From: Carl Moore 
Sent: 20 June 2018 11:37
To: Andrew Wood; Juan Baeza
Subject: FW: FG/95/18/HH - 25 South Drive, Ferring

I refer to the current planning application for a proposed 2 storey extension at the front of 25 South Drive in Ferring (FG/95/18/HH).

PROPOSED WEST ELEVATION 1:100

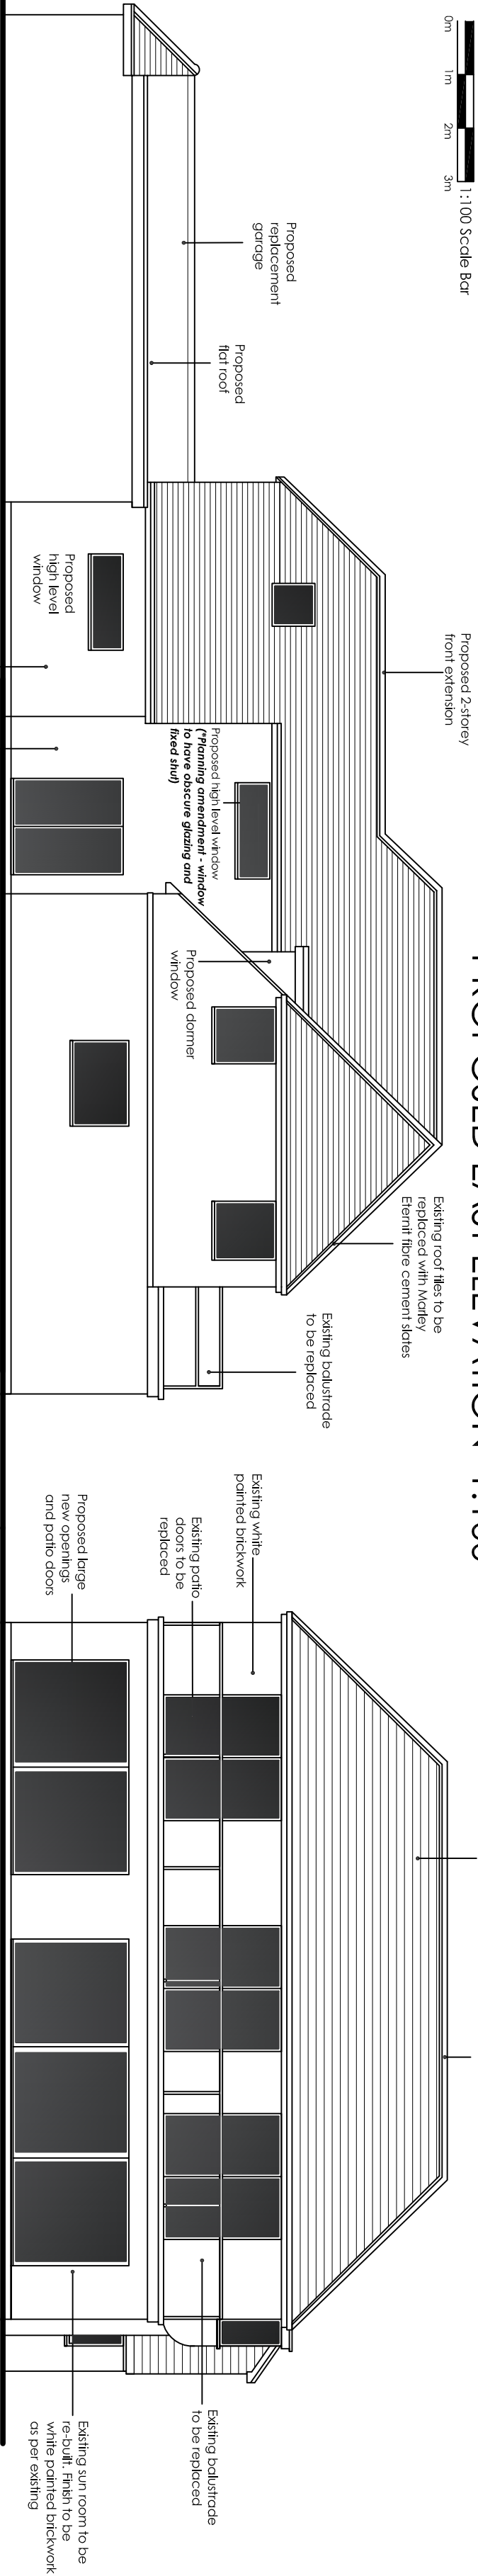
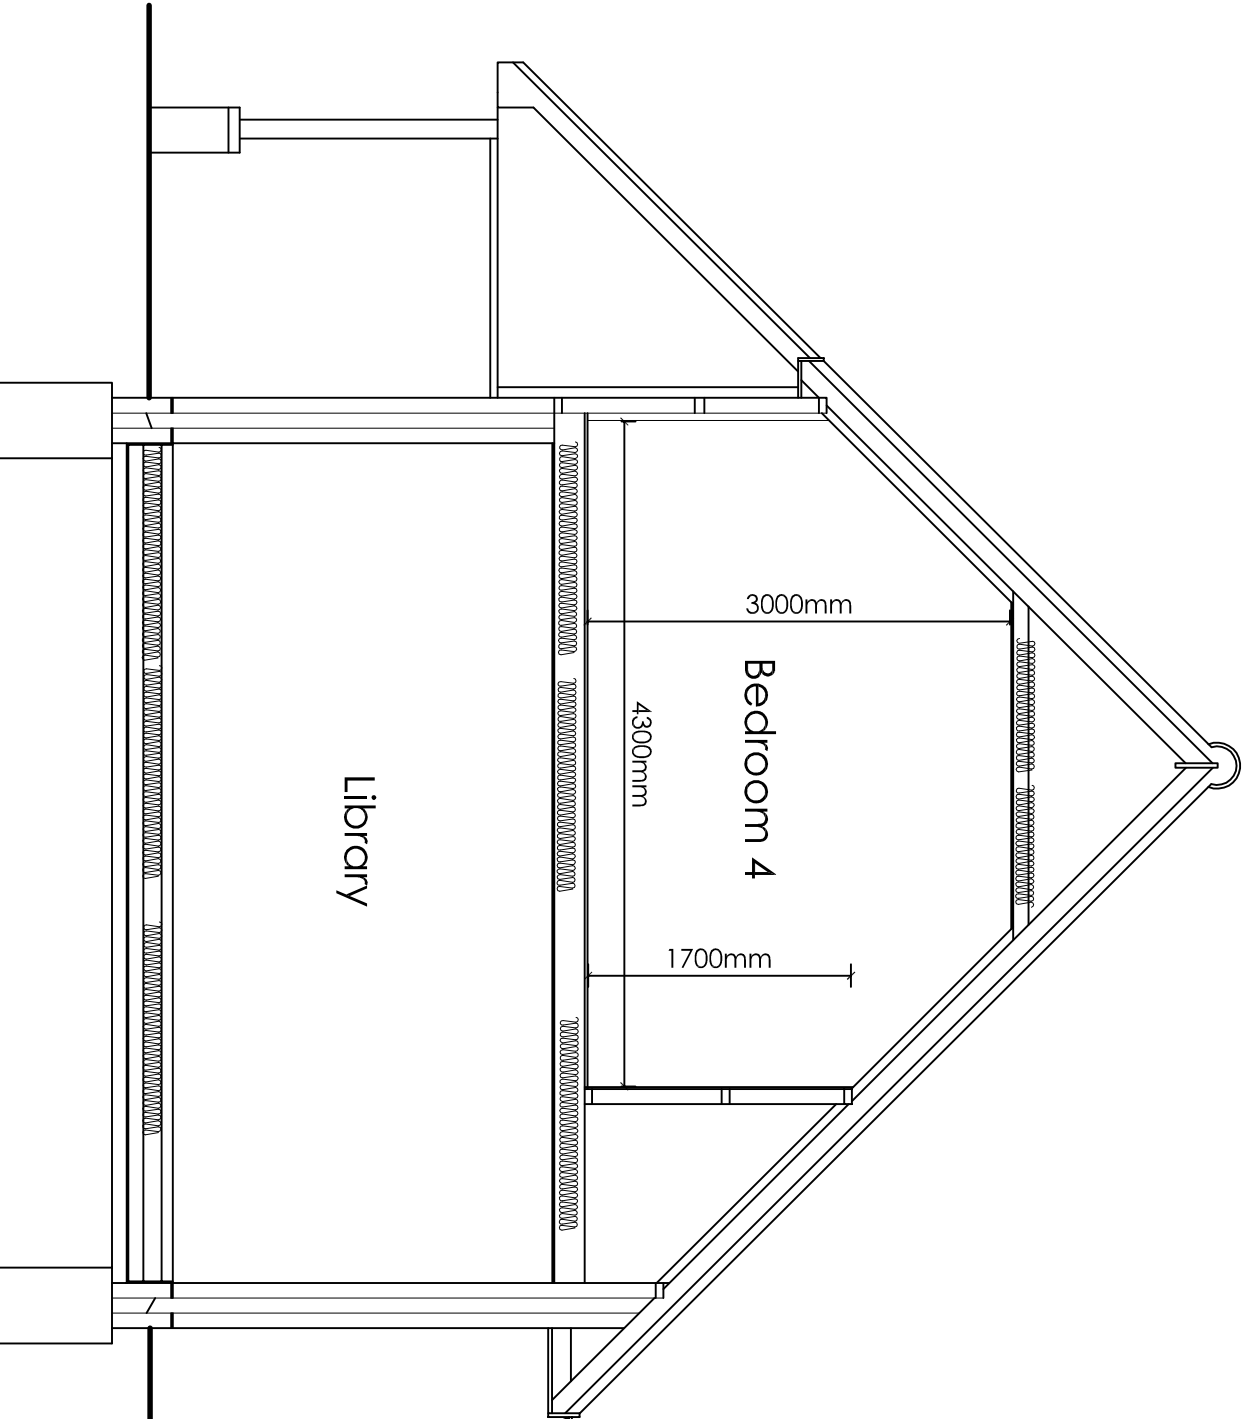
I understand that the neighbour at No.27 has submitted an objection with regard to the high level window on the west elevation. As suggested by the neighbour the client has agreed to obscure this window and ensure that the window is non-opening at all times. I have therefore attached amended drawings and included a note to confirm this suggestion. If the application is approved then please could you include a planning condition to cover this point.
